It is clear that the Milton / Eastney allotments and the Melville Rd leisure Park at Southsea are unique within this project due to HDD process going on beneath them (estimated 3 months period). Allotment holders, tenants and the occupants of mobile homes will be residing and working directly above the proposed HDD route.

In a further document submitted to the Examining Authority ' Further Written Questions Doc ref 7.4.3.4. Dated 25 Jan 2021 by the Applicant submitted a report supplied by Stockton Drilling Ltd dated 20 Jan 21.

Compulsory Aquisition Hearing 1 – Appendix 1
- Exhibit 15 Cross-section showing the typical
arrangement of the construction corridor
across Milton Common

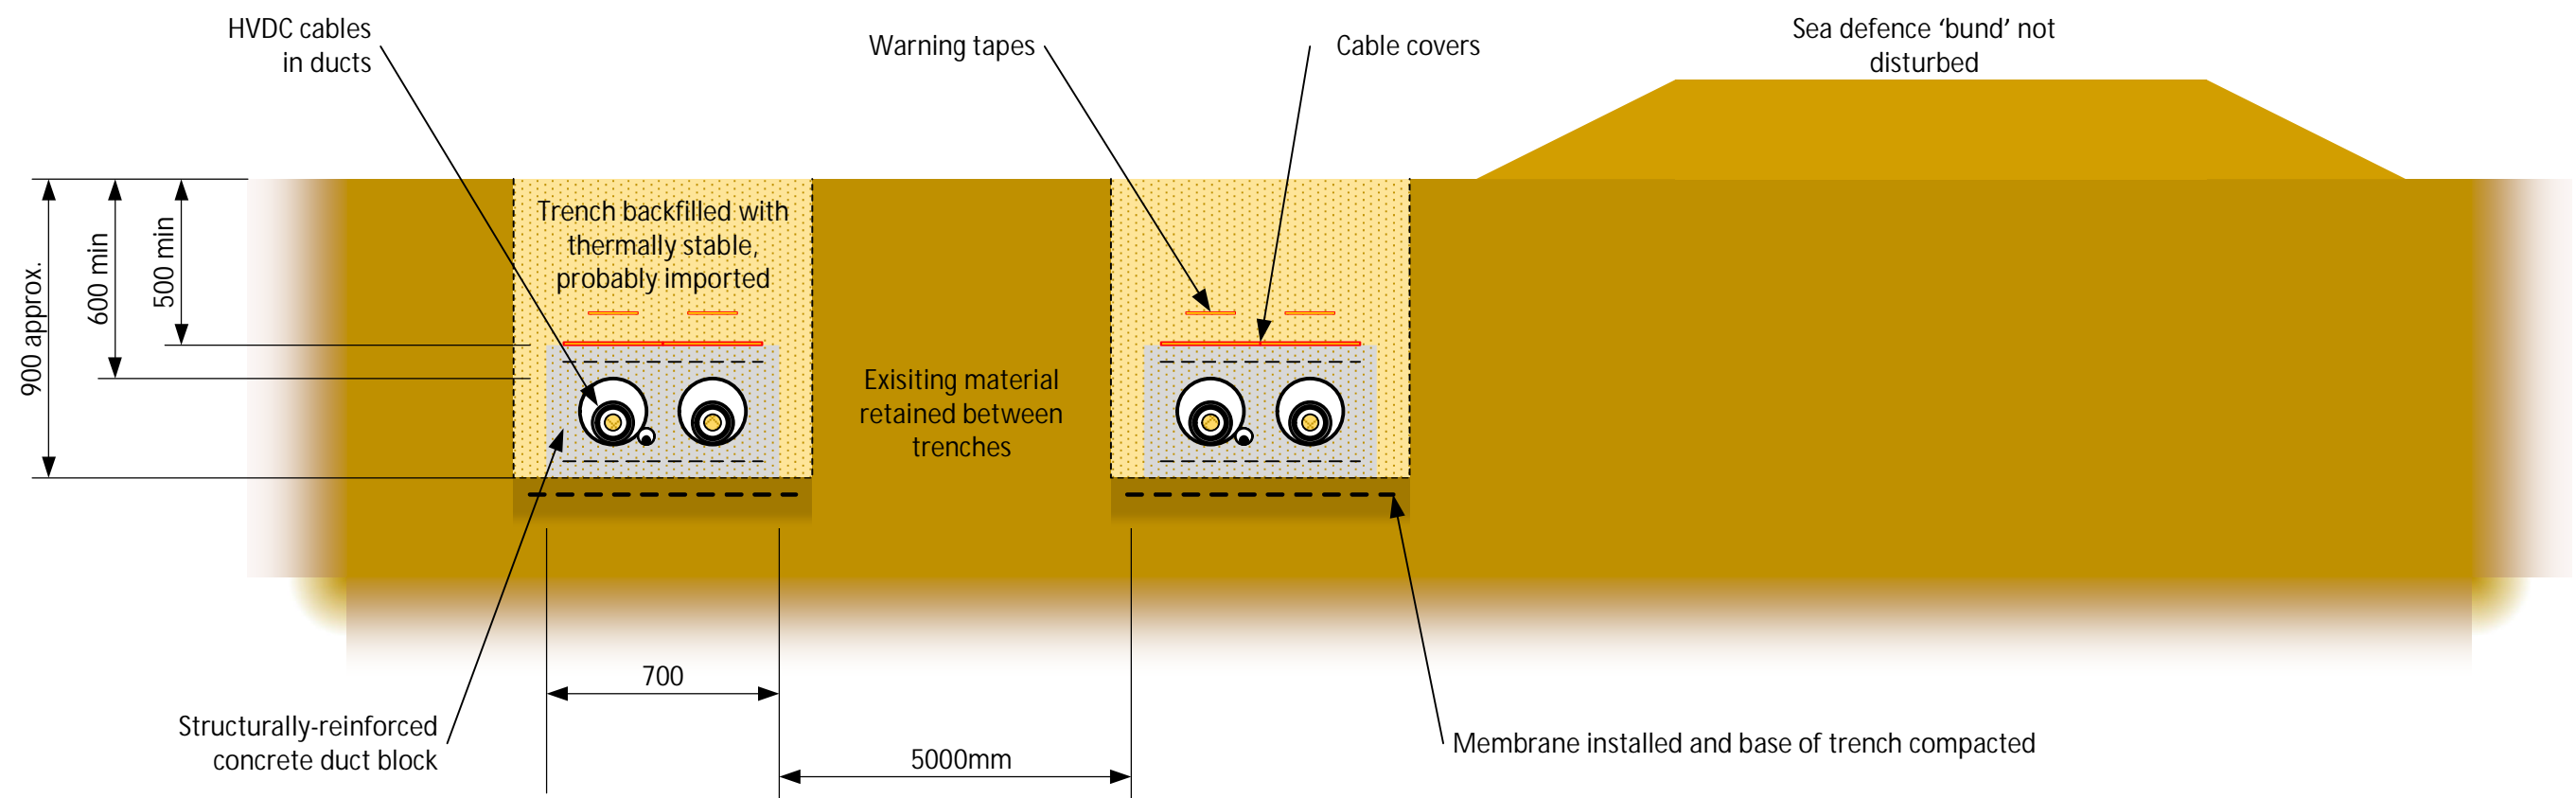
What are the diameter of the bore holes for each of the four power cables. What is the minimum distance that each cable or pair of cables have to be separated in the HDD proposed route?

It is clear that the applicant has, in reality, absolutely no idea what their proposed route over Milton Common is at this stage. Is this yet another issue for so called 'detailed design'. In other words, ' we are not sure, let see what happens'. Is that any way to apply for a planning application?
